A417 Missing Link DCO

Joint Councils Written Submission of case put orally at the Hearings held the week commencing 24 January 2022

Gloucestershire County Council, Cotswold District Council,
Tewkesbury Borough Council

2 February 2022

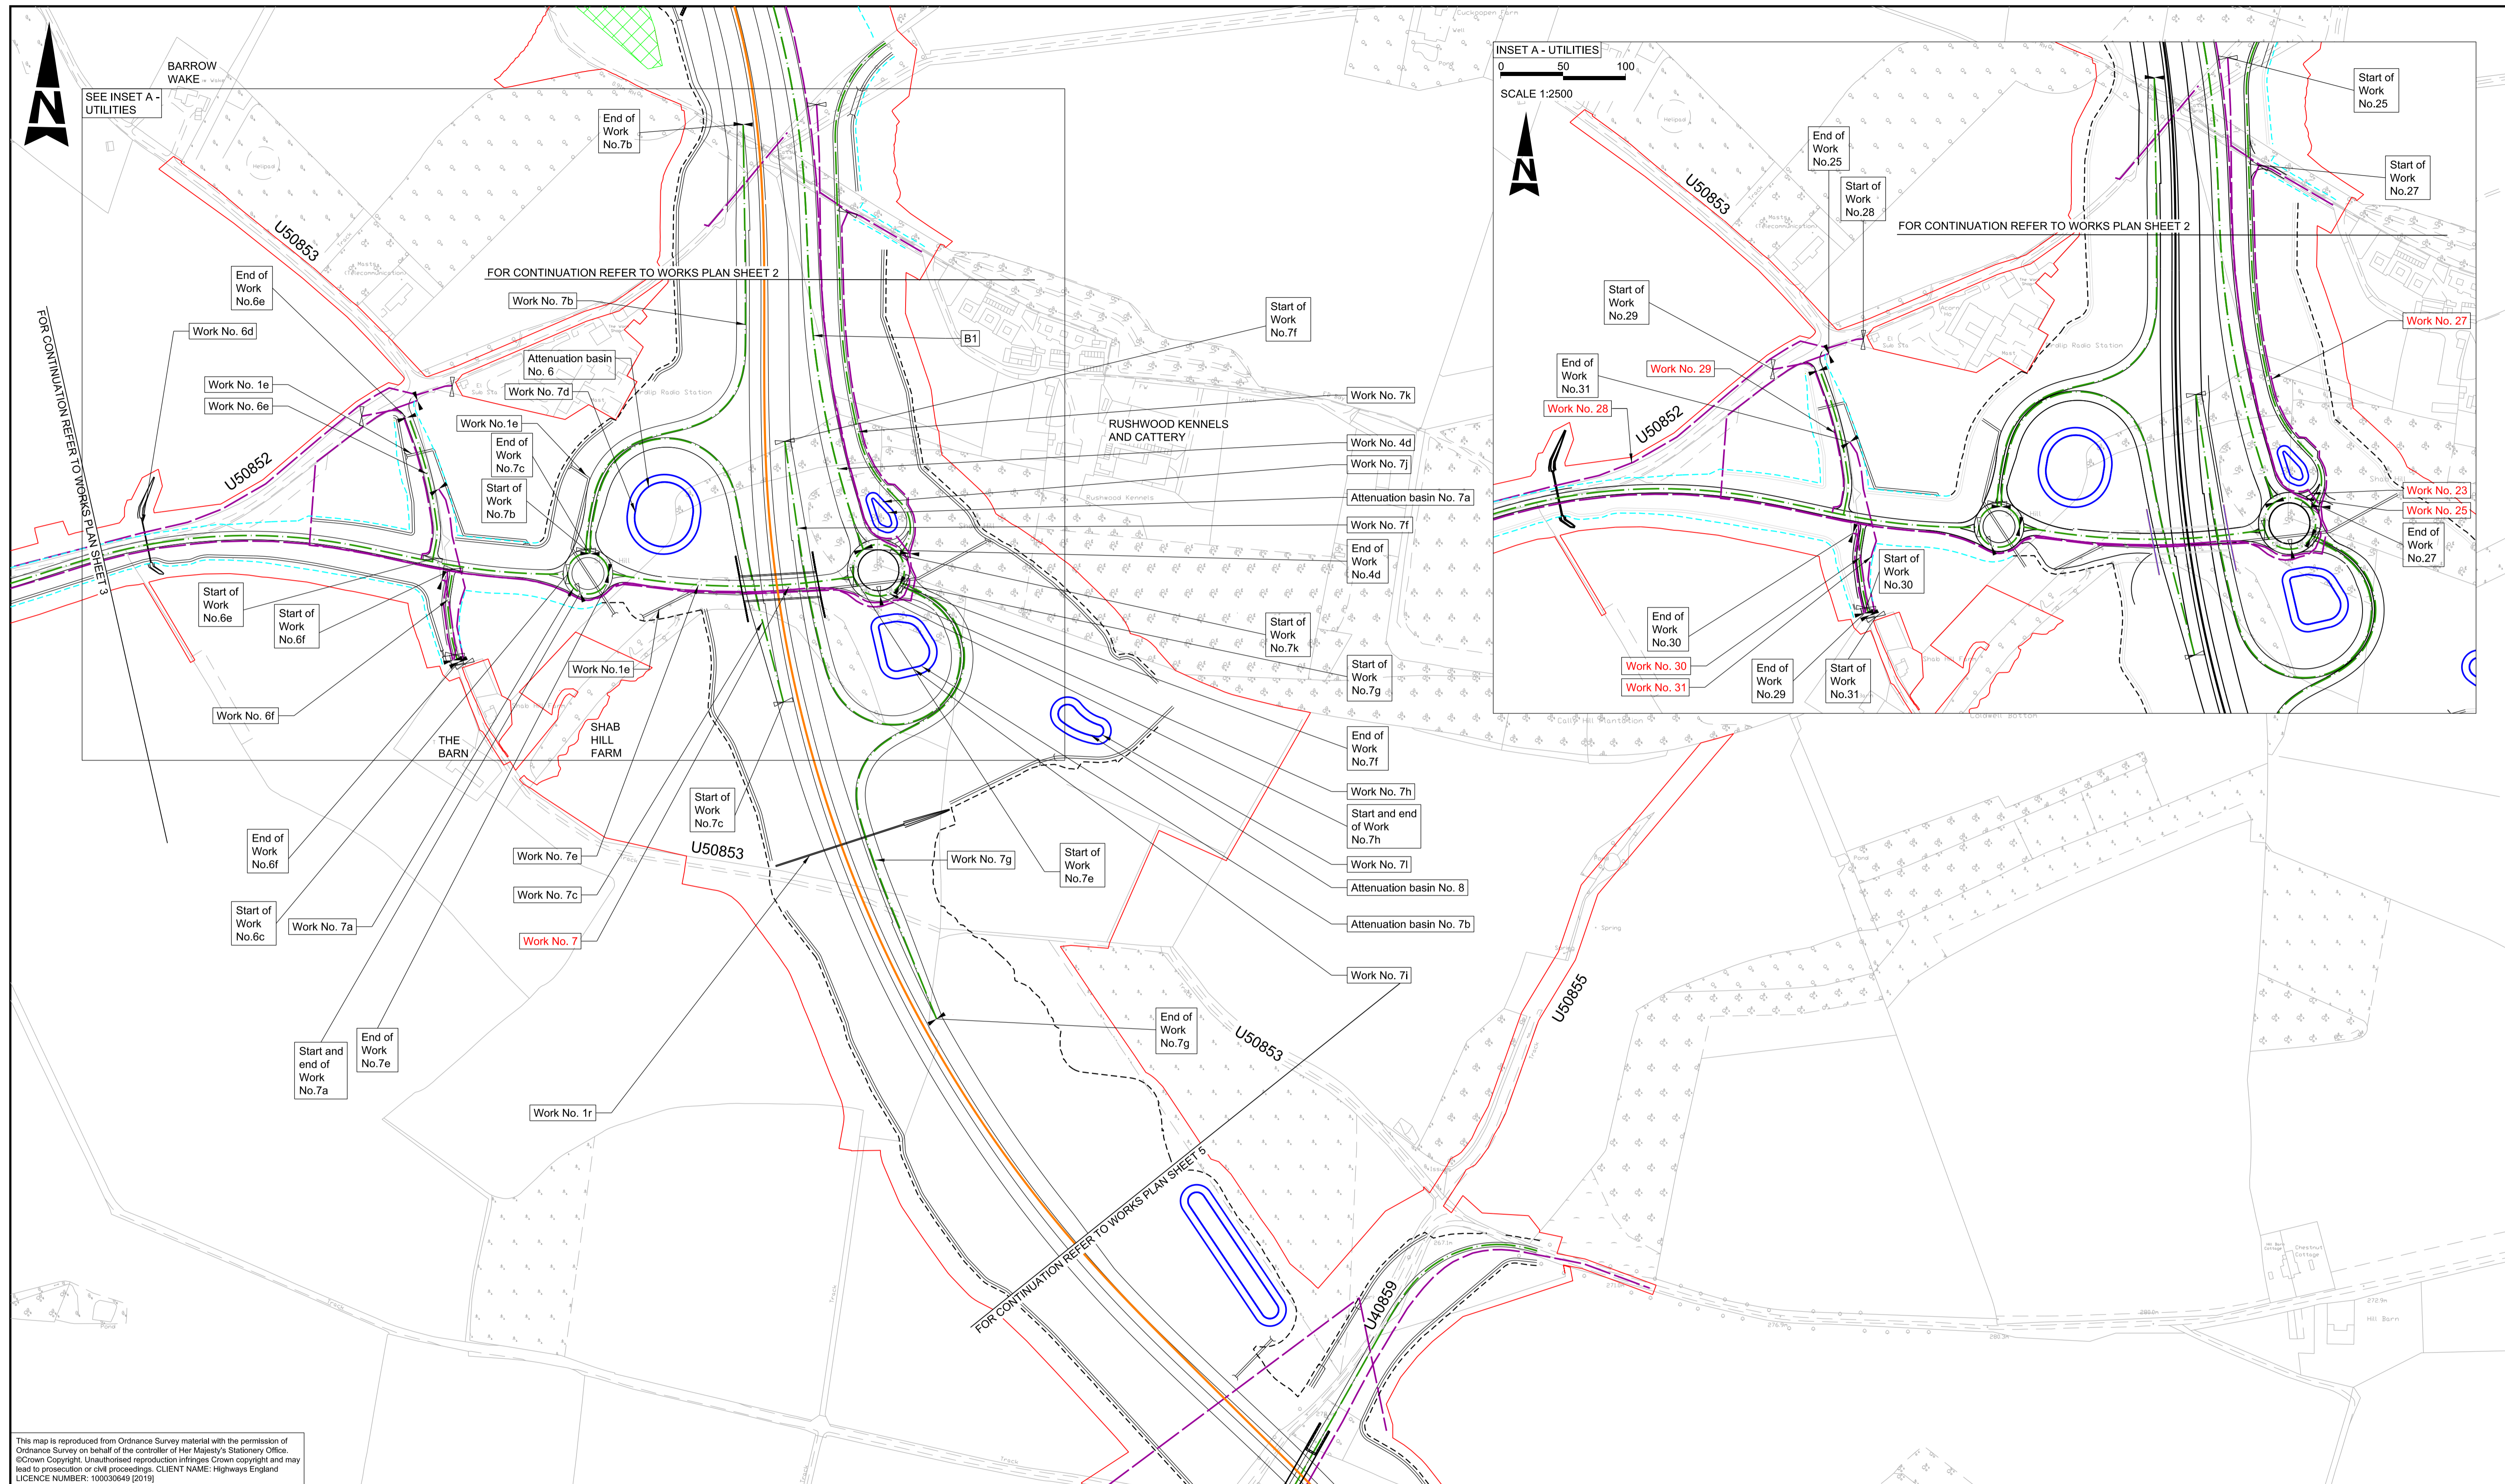
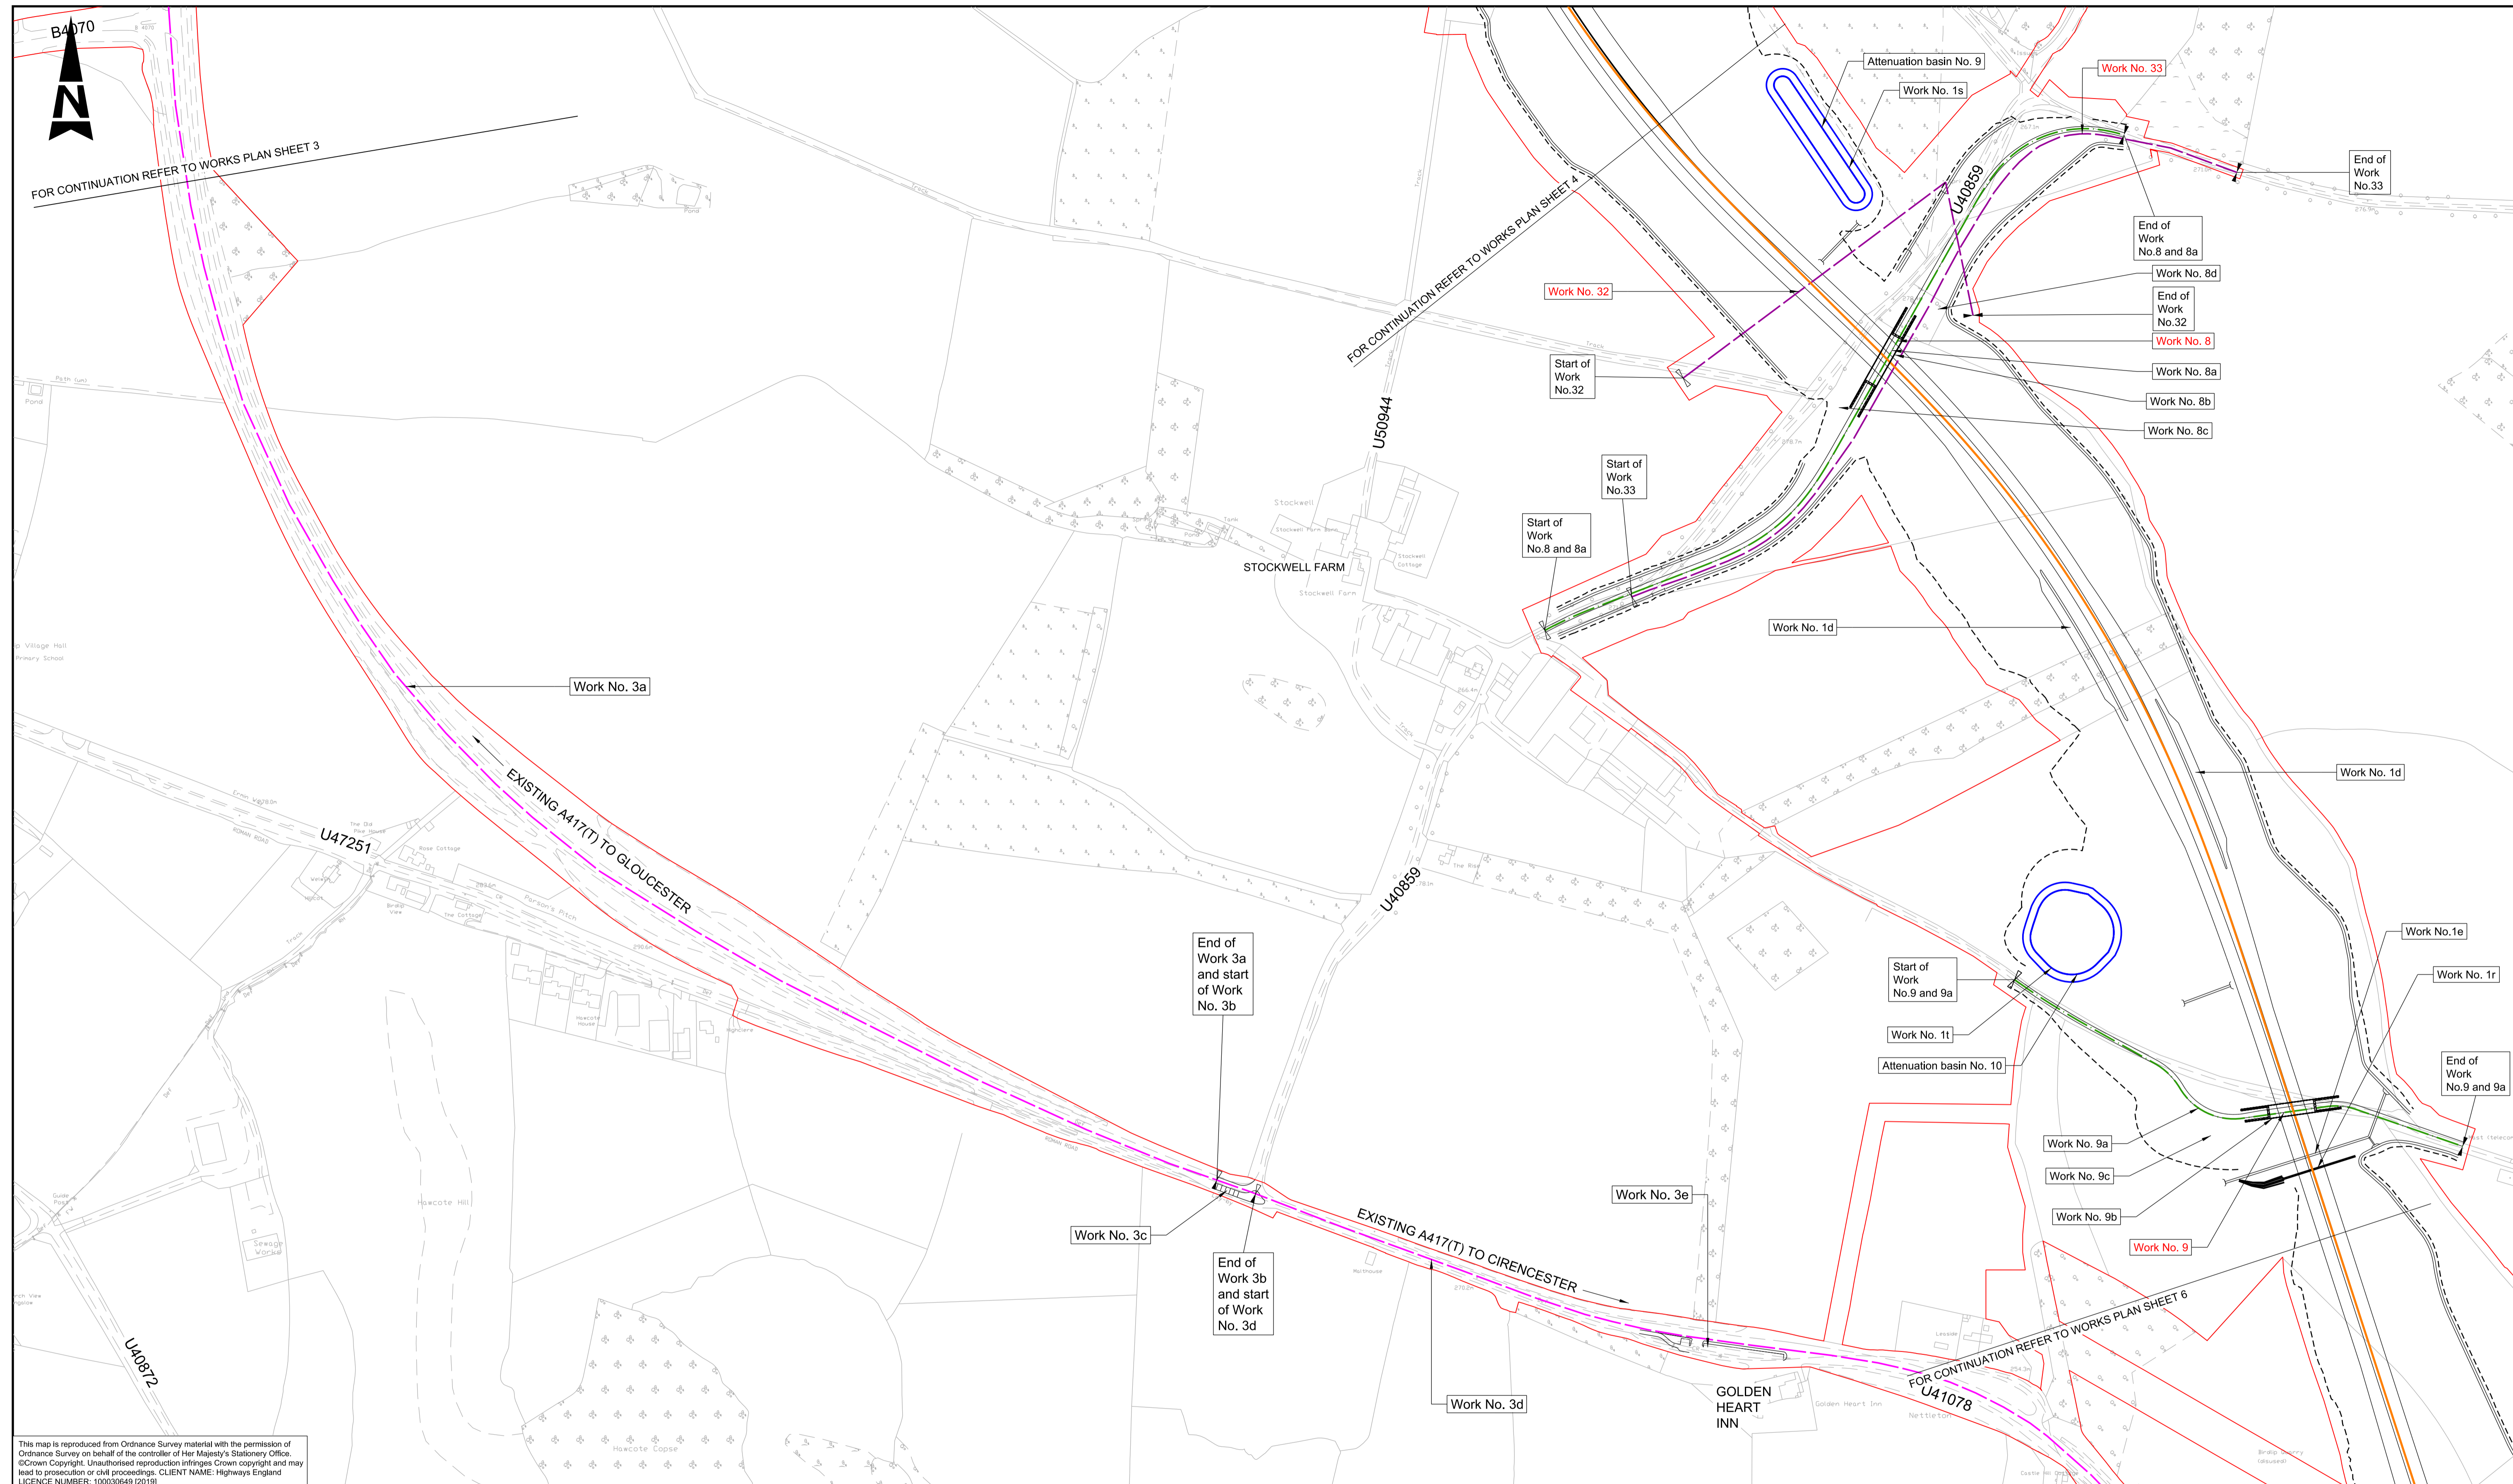
- There is a lack of preliminary design information for the proposed National Trail included on the general arrangement plans and works plans to be secured under Requirement 11 Detailed Design and a lack of design detail in the National Trail Diversion Report secured under Article 20.
